## **North Wales Local Authorities Expert Topic Group's response to the SLVIA and LVIA submitted with the DCO application at the Deadline 1 stage of the Awel y Mor Offshore Wind Farm Proposal October 24 2022**

Please find below our collective response to the SLVIA and LVIA submitted with the DCO application for the proposed Awel y Môr Offshore Wind Farm (AyM OWF). Following an extension of a funding opportunity presented by RWE, the LUC was appointed once again by a group of seven North Wales Local Planning Authorities in August 2022 to undertake an updated review of SLVIA/LVIA matters with regards to the Awel y Môr Offshore Wind Farm (AyM OWF). The LUC had previously been appointed by the group in July 2021 to undertake a review during the PEIR stage, which was submitted alongside LPA comments during that time. The proposed wind farm comprises of onshore and offshore elements and potential effects resulting from these are reported separately. A copy of this report is included with this letter.

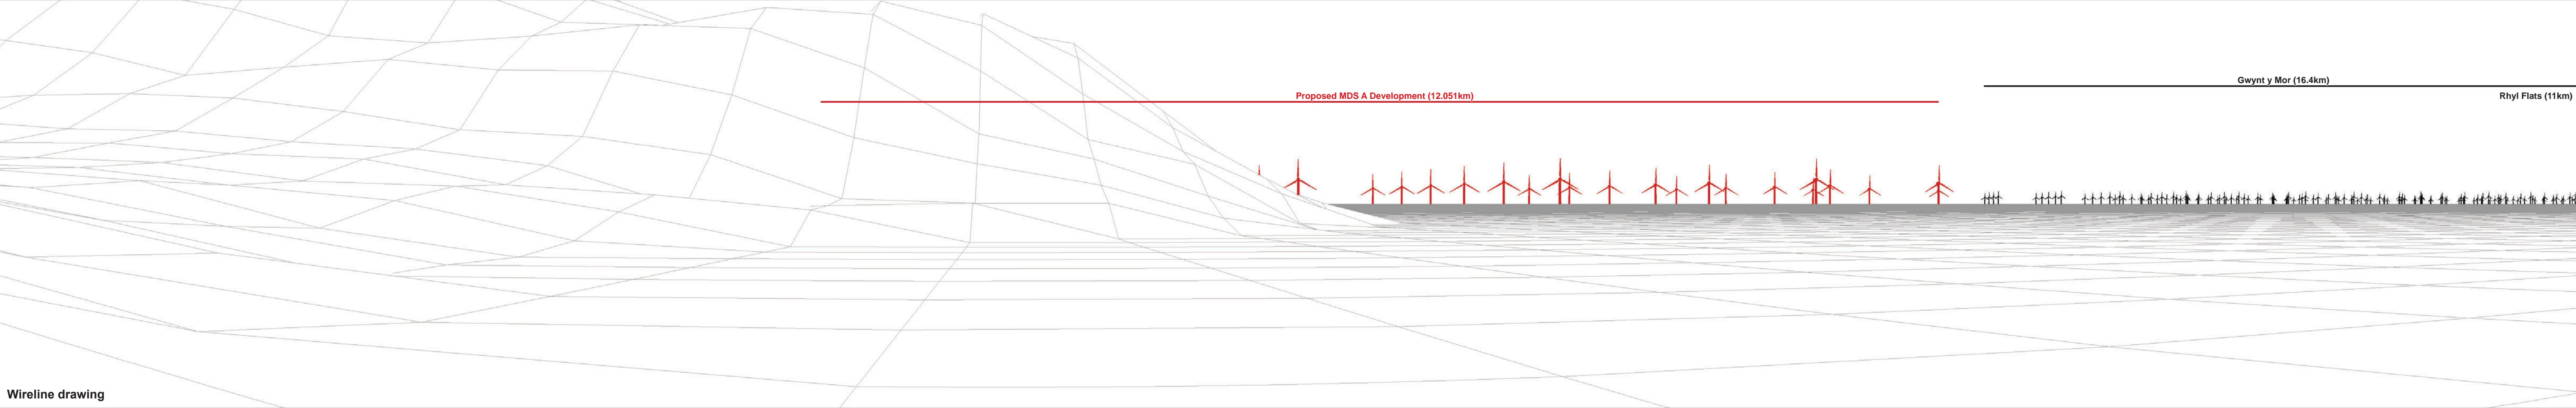
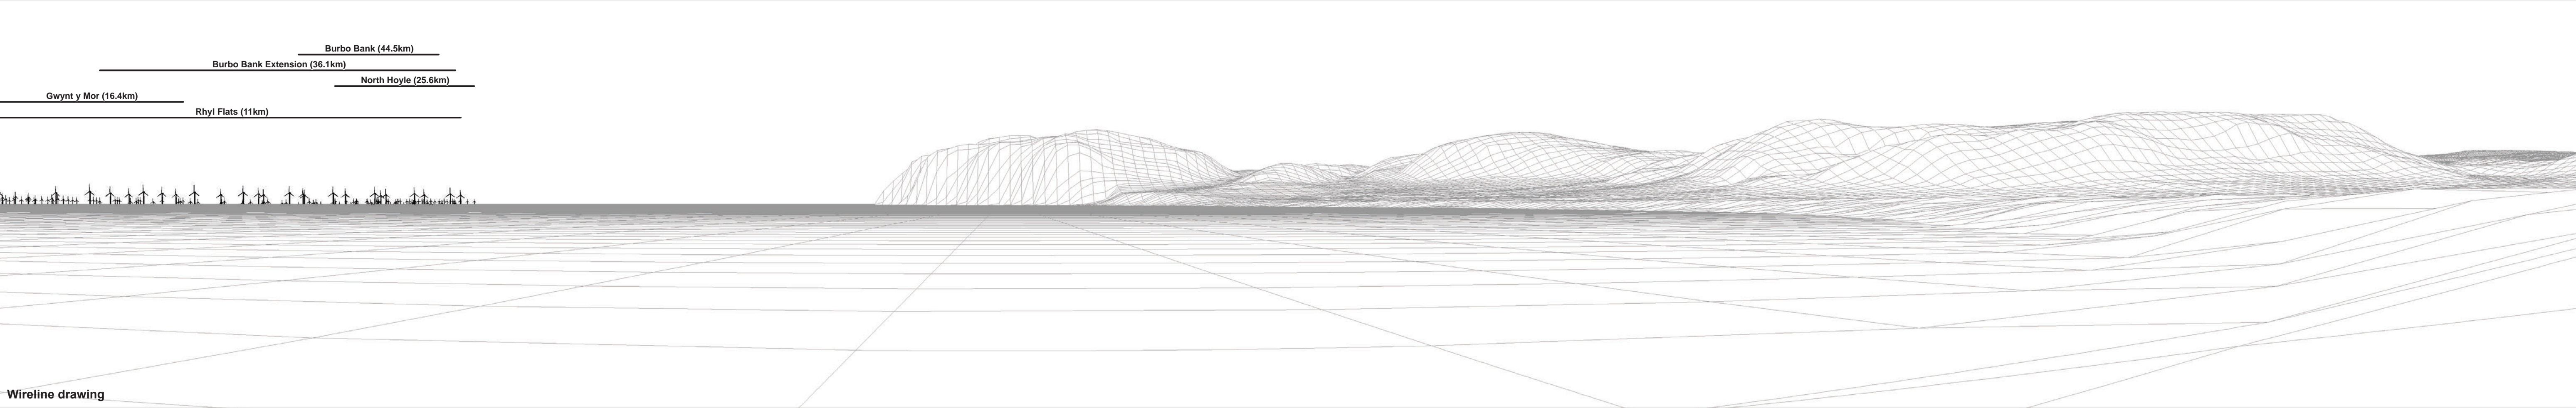
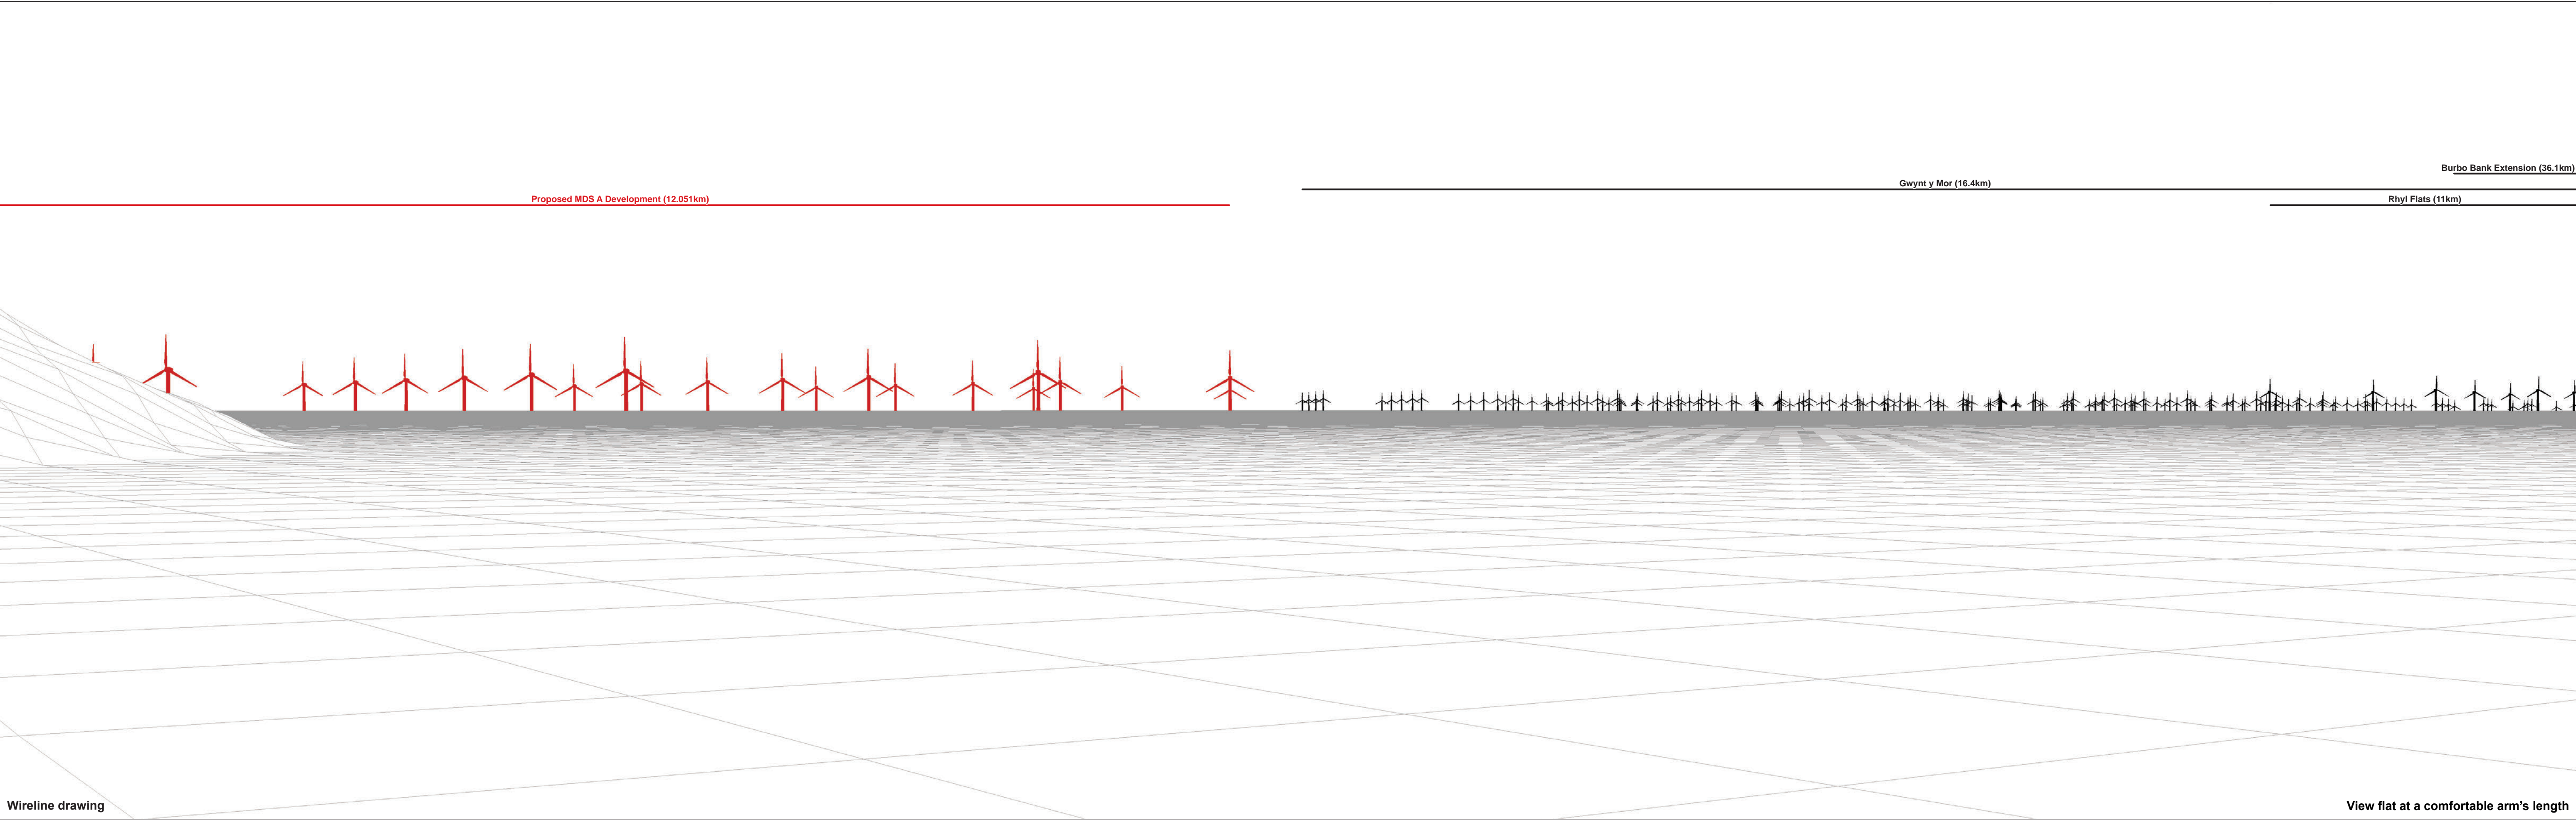
The impact of the AMOWF on the setting of views towards, and from, the Great Orme and Little Orme is illustrated in particular in the following images in the SLVIA:

Figure 82b, 82c and 82e Llandudno promenade – lifeboat slipway (12.051km)

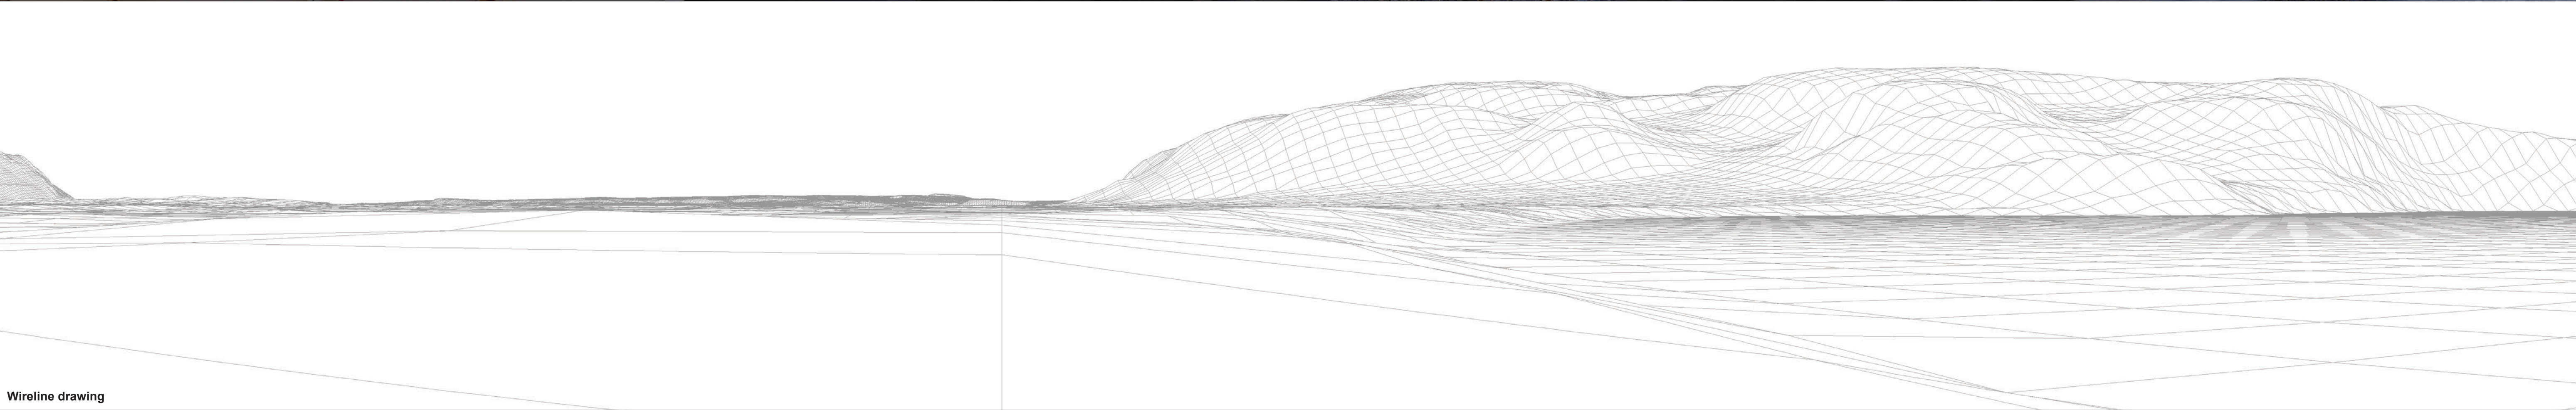
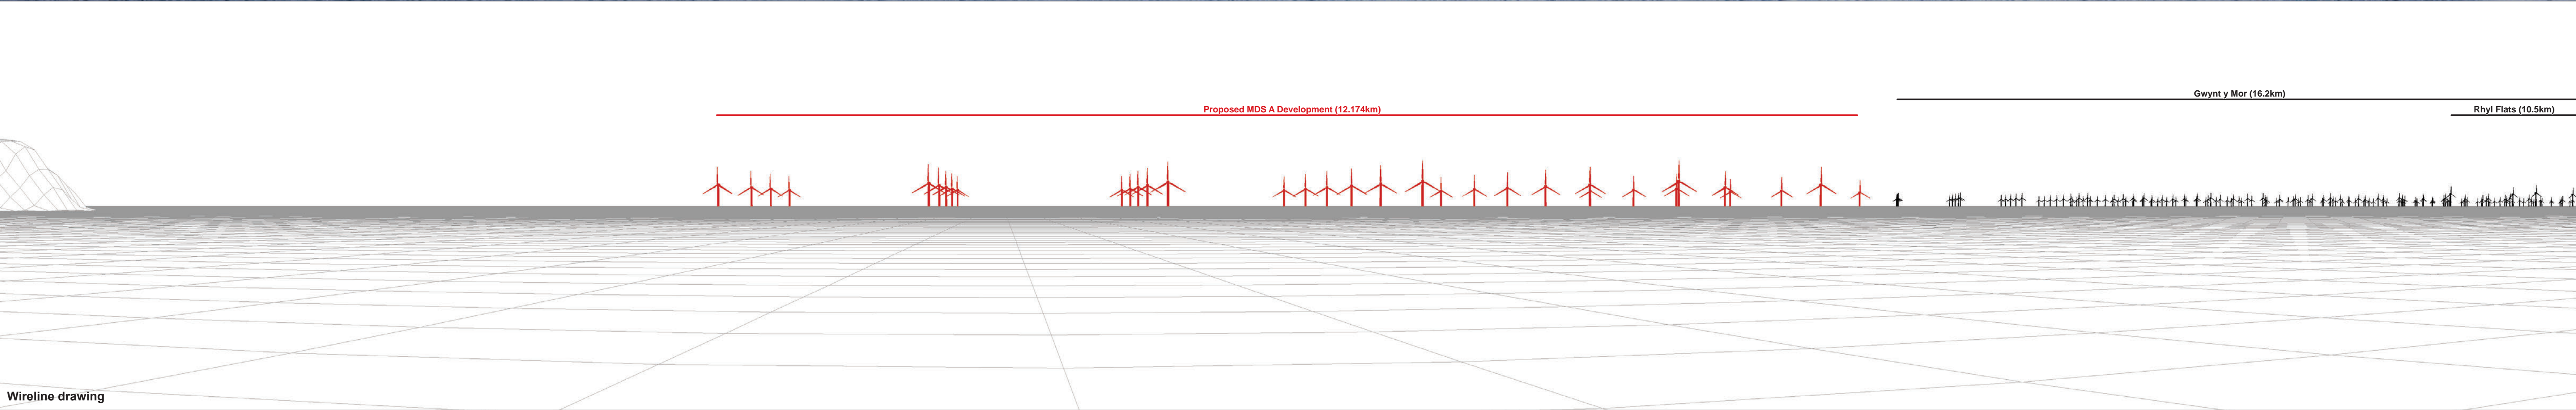
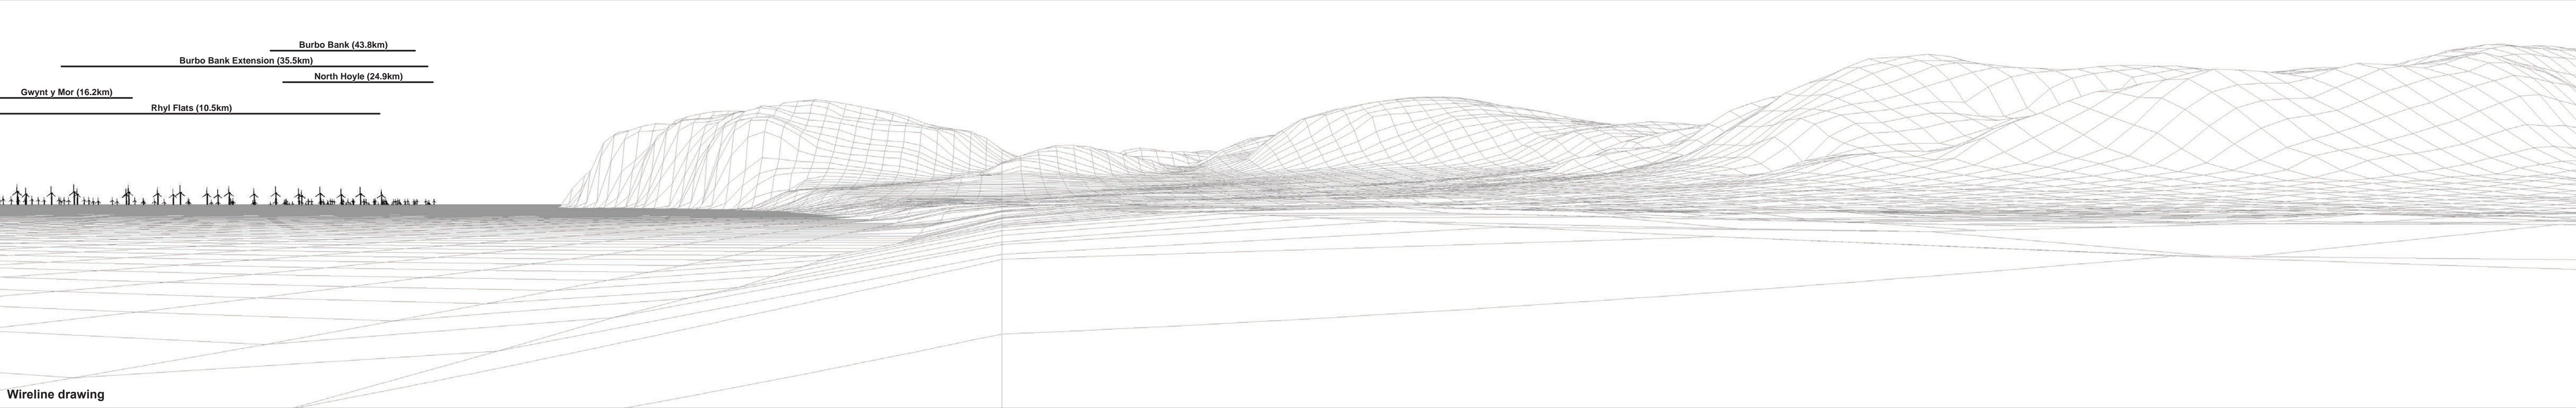
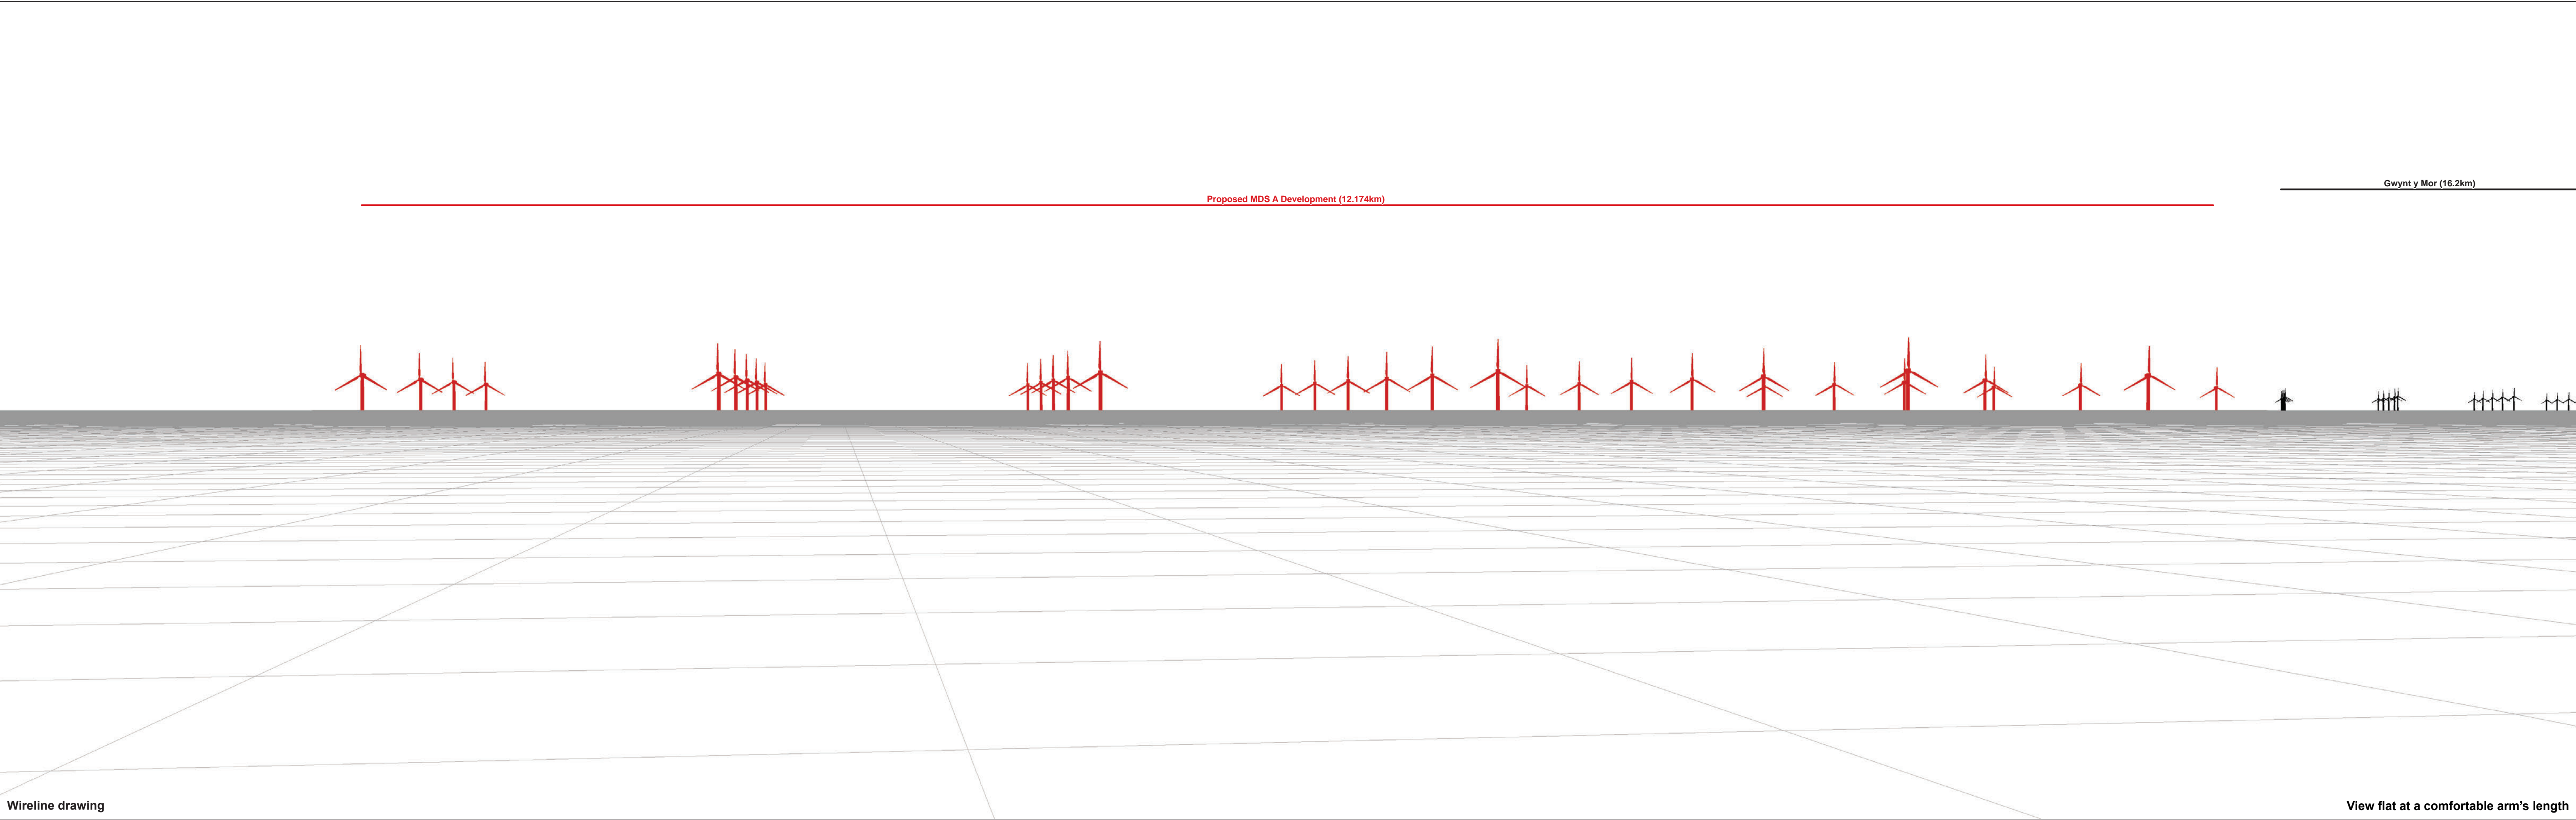
Figure 84c and 84h: Llandudno Promenade near Venue Cymru (12.174km)
